Re: **30&32a HIGH STREET, ARUNDEL – AB/94/19/HH and AB/94/19/L**

With regards to the above referenced planning application, I herewith present the following information to discharge the conditions on the planning application:

Project No: Drawing No: Revision:
20026 002 C

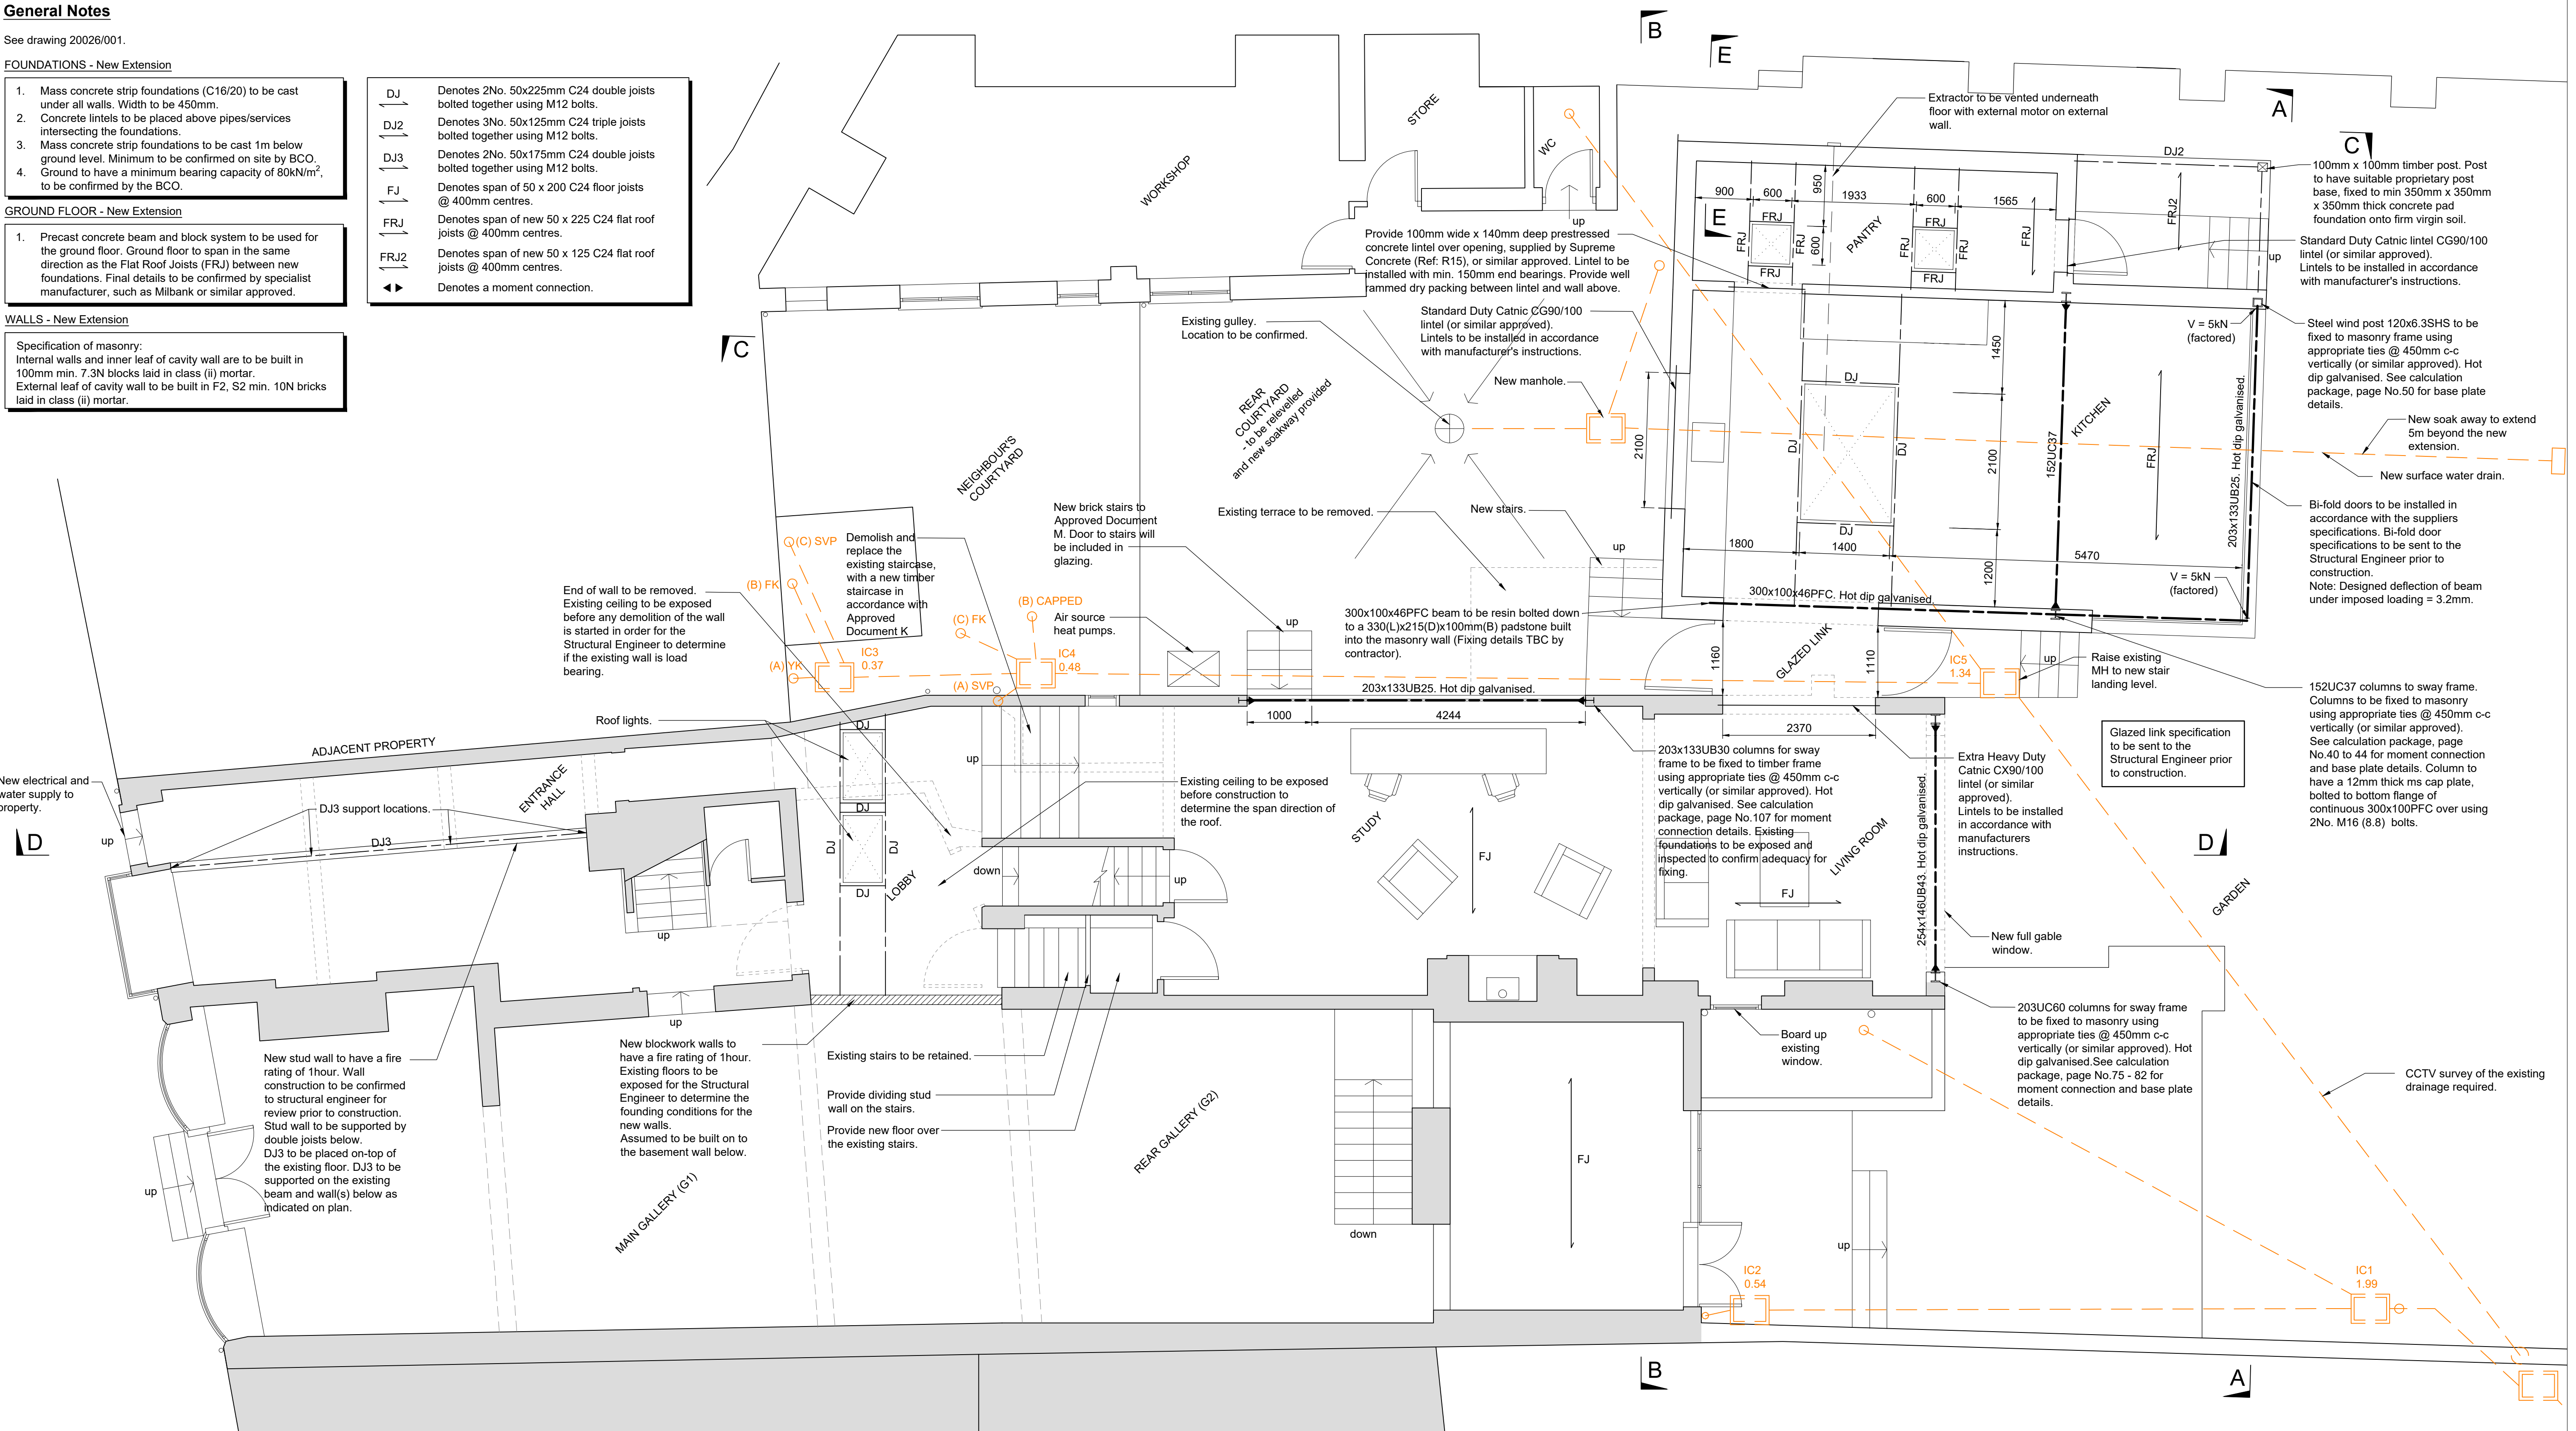
- 4.1 A canopy over the porch has been added to the north-east corner of the new extension. Refer to drawing 002.
- 4.2 The sedum covering on the flat roof of the new extension has been omitted.
- 4.3 The window on the west side of the new extension has reduced to 2.1m in length.

Project No: 20026
Drawing No: 004
Revision: C

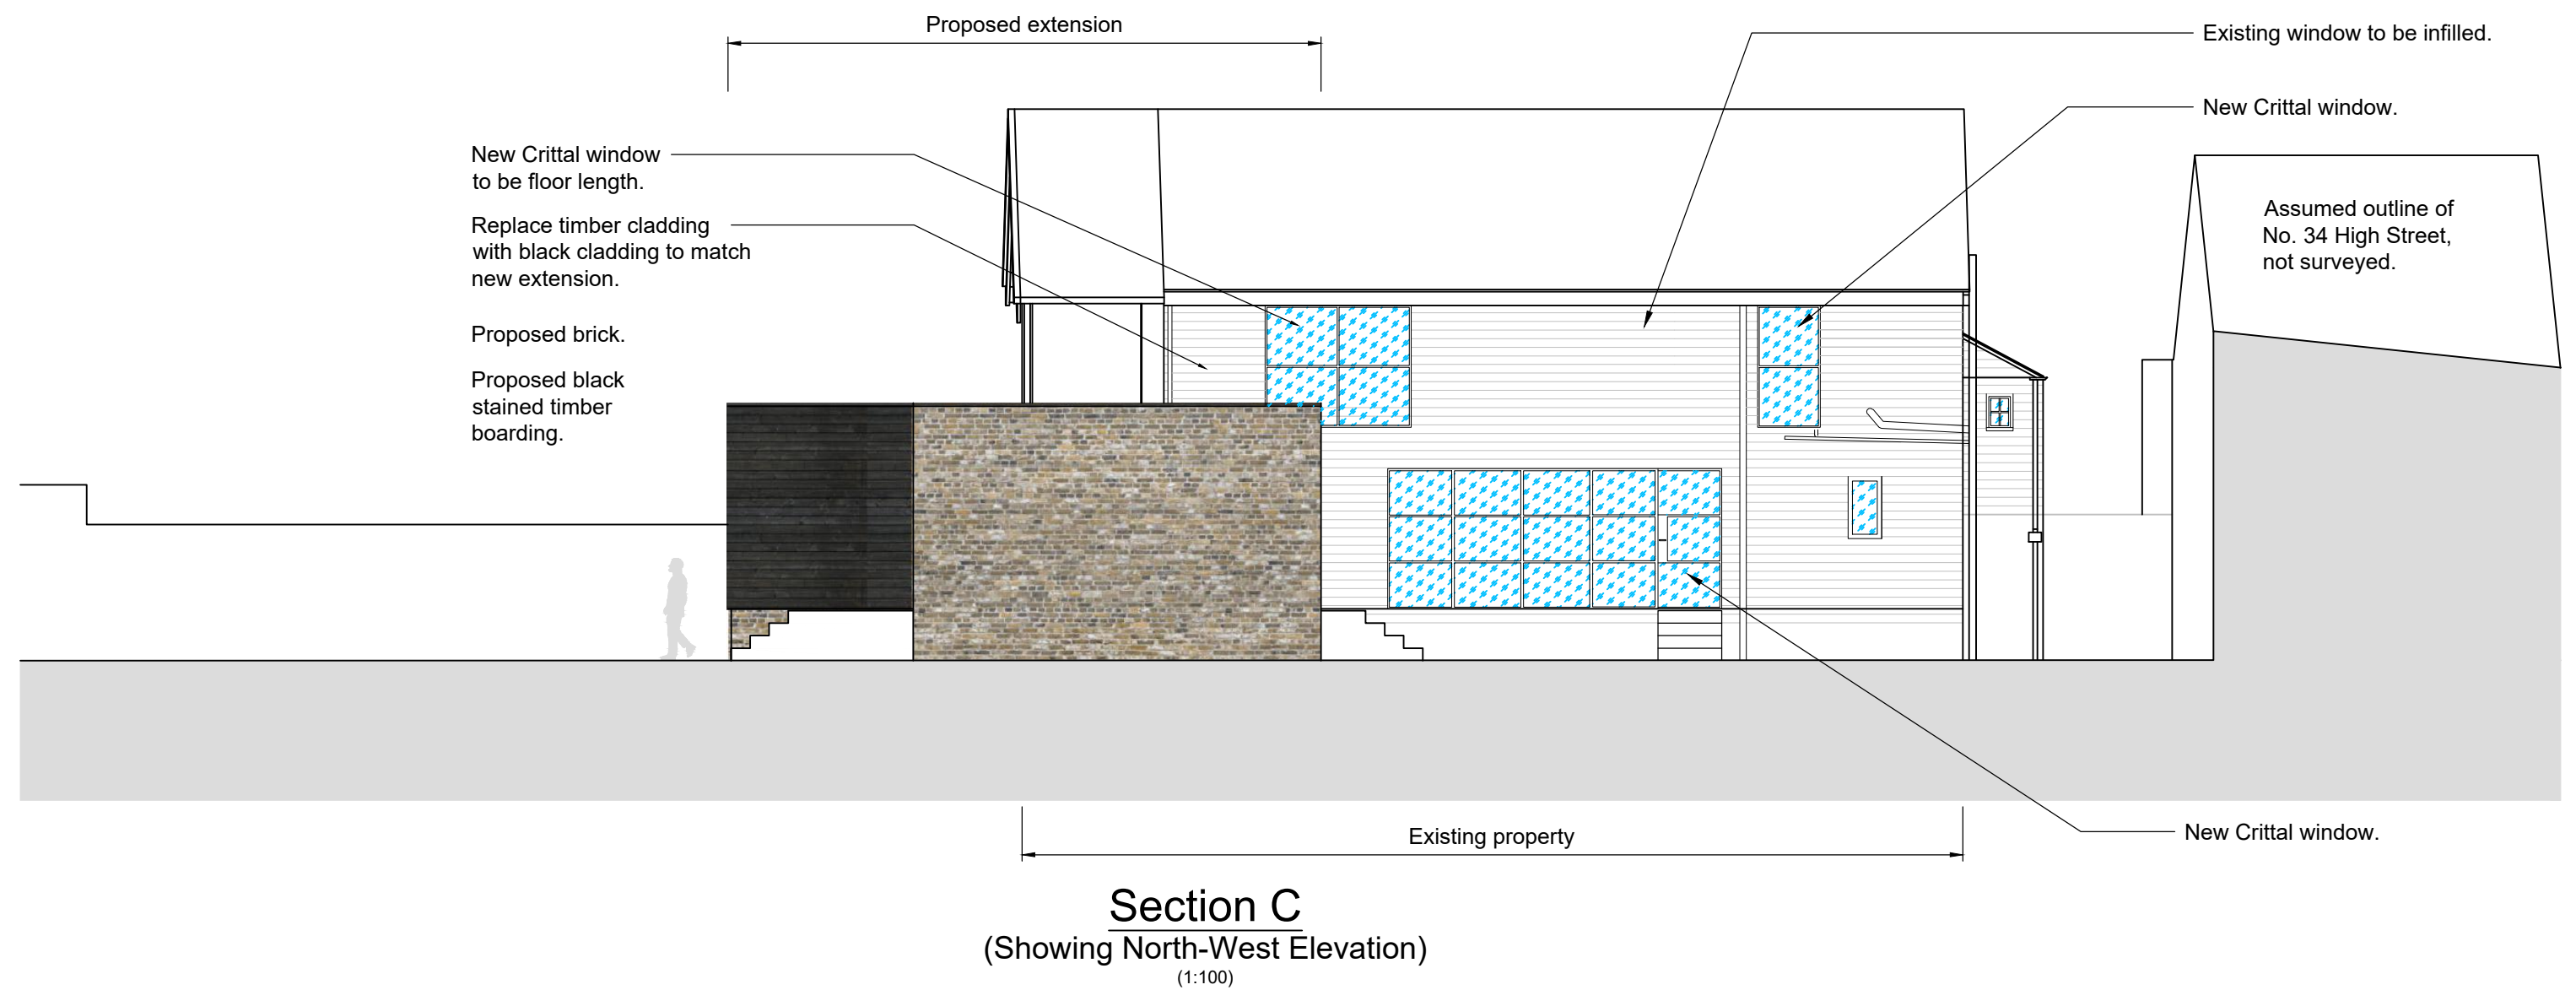
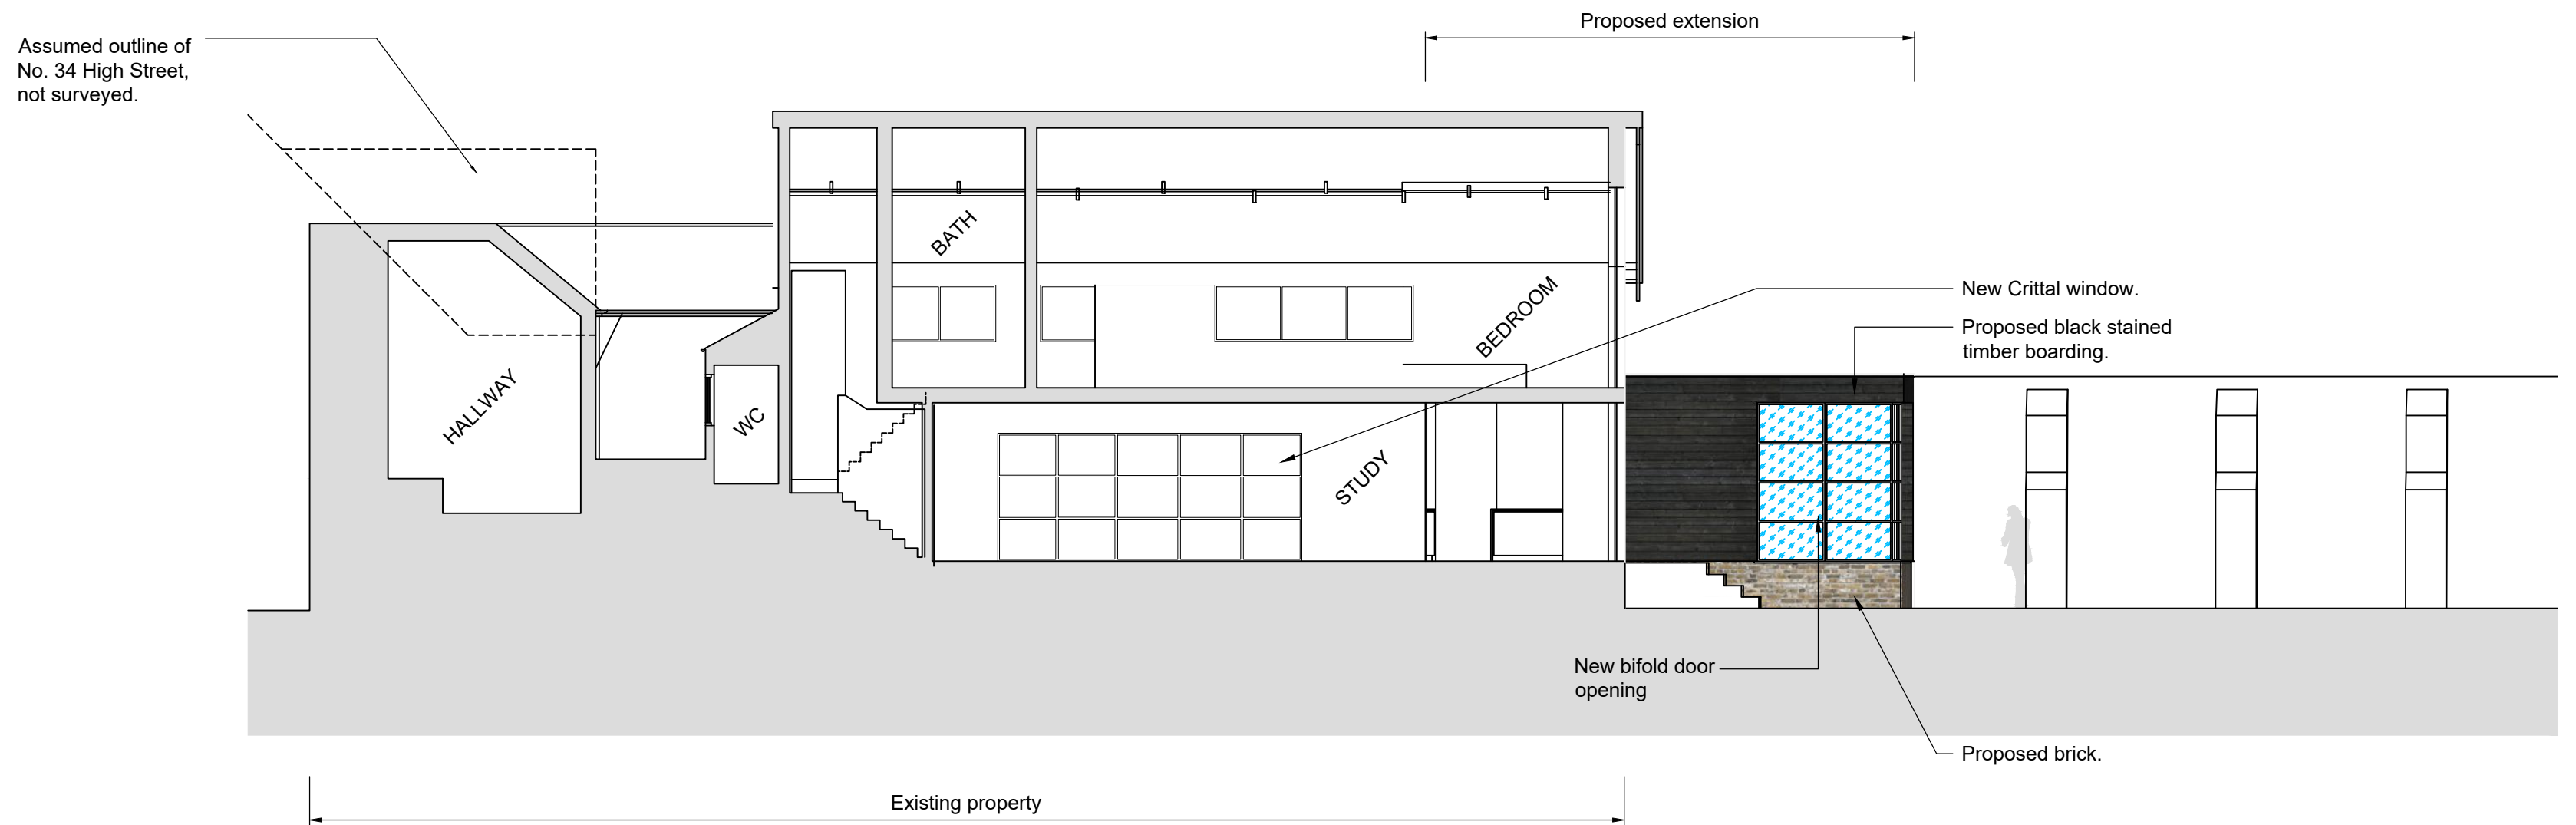
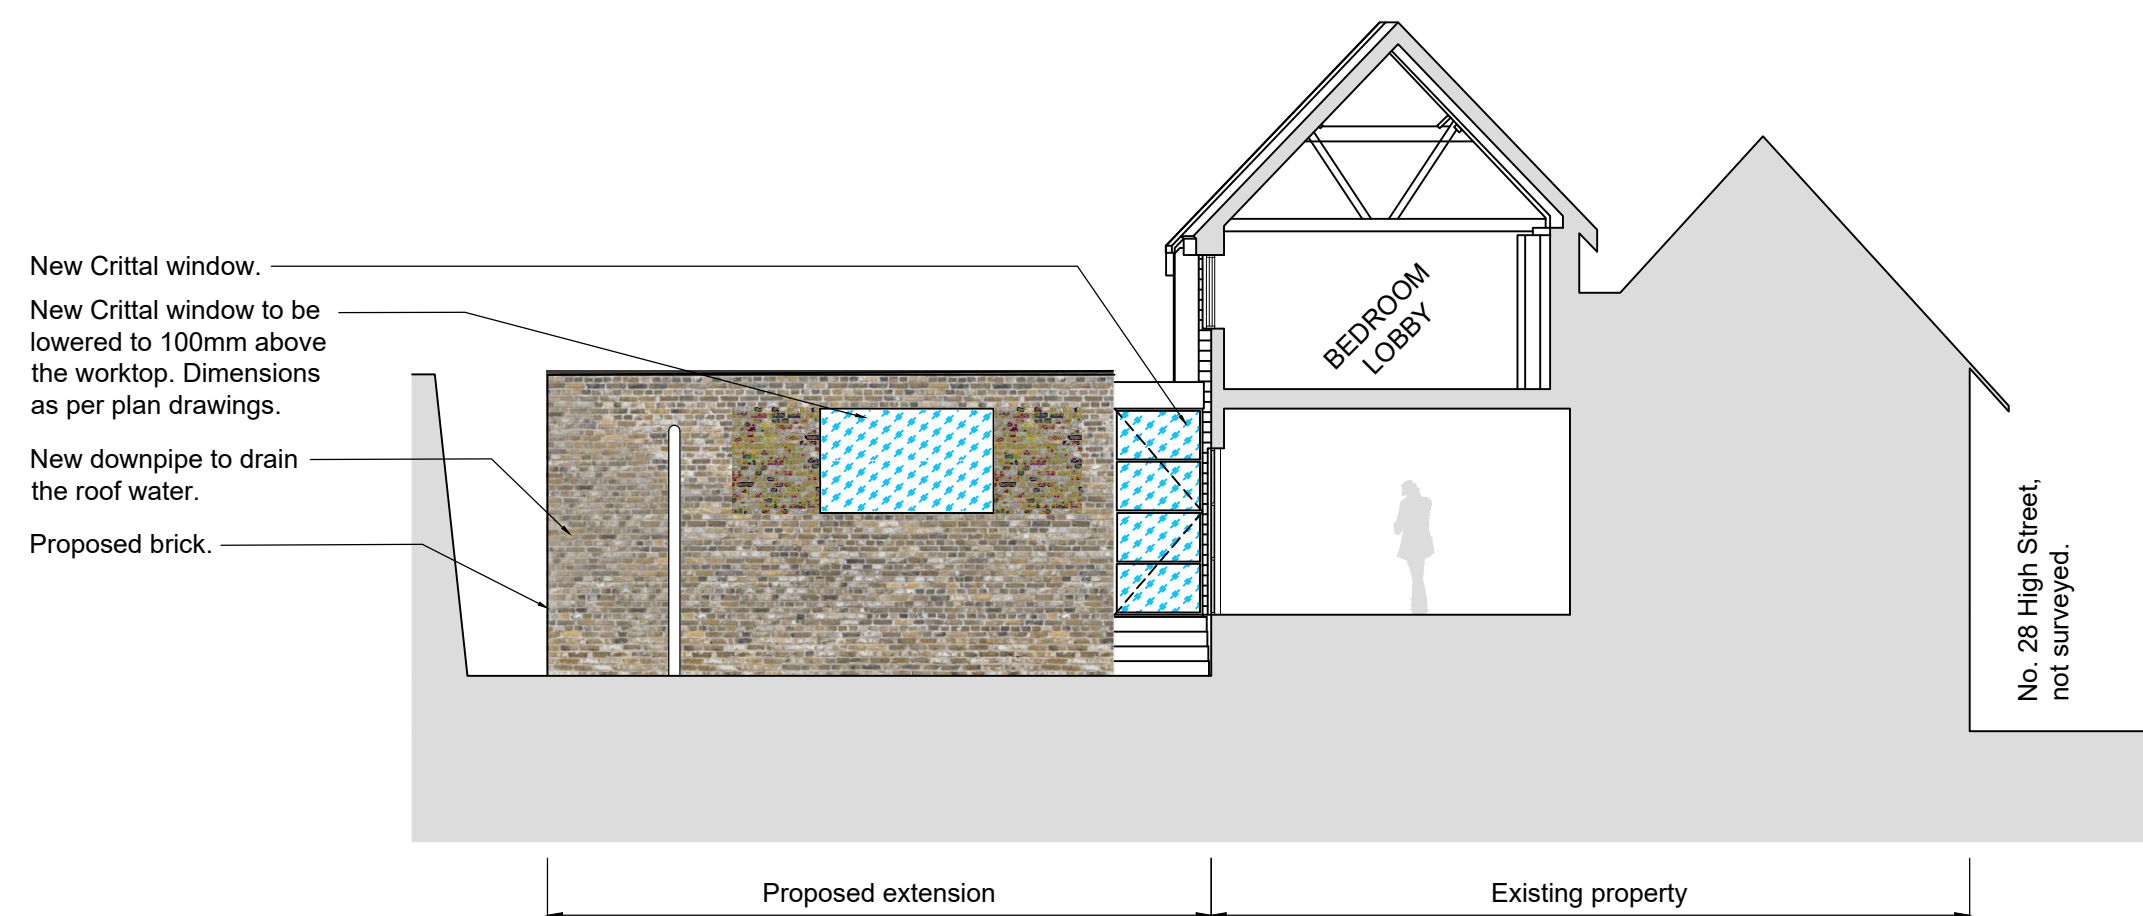
- 3.1 The brick blend finish will extend from ground level to the top of the parapet on the north-west, south-west and the porch section of the north-east walls. In all other locations, the brick blend finish will extend up to floor level.
- 3.2 The black-stained timber boarding will extend from the floor level to the top of the parapet the north-east and a section of the north-west walls.

The above schedule of material is graphically presented on drawing No. 004.
